<b>Application Reference Number:</b>	2025/0231
--------------------------------------	-----------

<b>Proposal Description:</b>	Change of use of former first floor accountants office to 2 bedroom residential apartment(C3) and associated external changes
------------------------------	---

<b>Location:</b>	69 High Street, Dodworth, Barnsley, S75 3RQ
------------------	---

Proposed Side Elevation

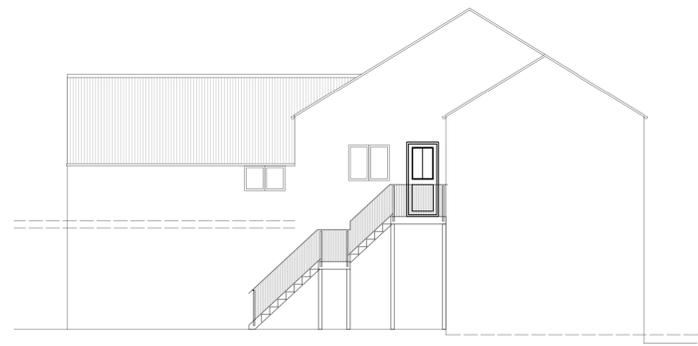
The dwellings to the west also form part of the terrace as it continues onto Jermyn Croft. Croft Cottage 28 Jermyn Croft is the furthest of these and is approximately 10 metres away facing the side elevation at an angle. The only external changes affecting these properties are the external staircase and door it serves. The windows as discussed above are existing.

The external staircase has a standing area at the top, which is approximately 1.5 square metres, this is not deemed to be large enough to cause significant overlooking nor be usable as amenity space. Movement on the stairs would be fleeting, and a real effort would be required to look into the neighbouring windows. The addition of a door is also not impactful. The balcony has been amended to a Juliet balcony which is deemed acceptable and reduces the impact of overlooking as there is no external projection. This weighs moderately in favour of the proposal.

Proposed Rear Elevation

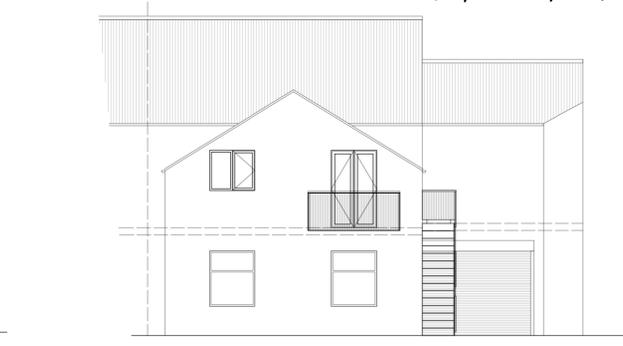
- Alternative design solutions not explored
- Could a Juliet balcony be used
- Could the proposed staircase be located on the other side of the building
- Inadequate justification for design
- Loss of privacy from the proposed balcony
- Loss of privacy from the proposed external staircase
- Overbearing impact of proposed balcony
- Overbearing impact of proposed staircase
- Overlooking from the proposed balcony
- Overlooking from the proposed external staircase
- Proposed balcony would be visually intrusive
- Proposed staircase would be visually intrusive

A further re-consultation was undertaken following the submission of amended plans which removed the balcony projection and replaced it with a Juliet balcony with inward opening doors. No further objections or comments were received.

- Alterations to balcony to remove external projection
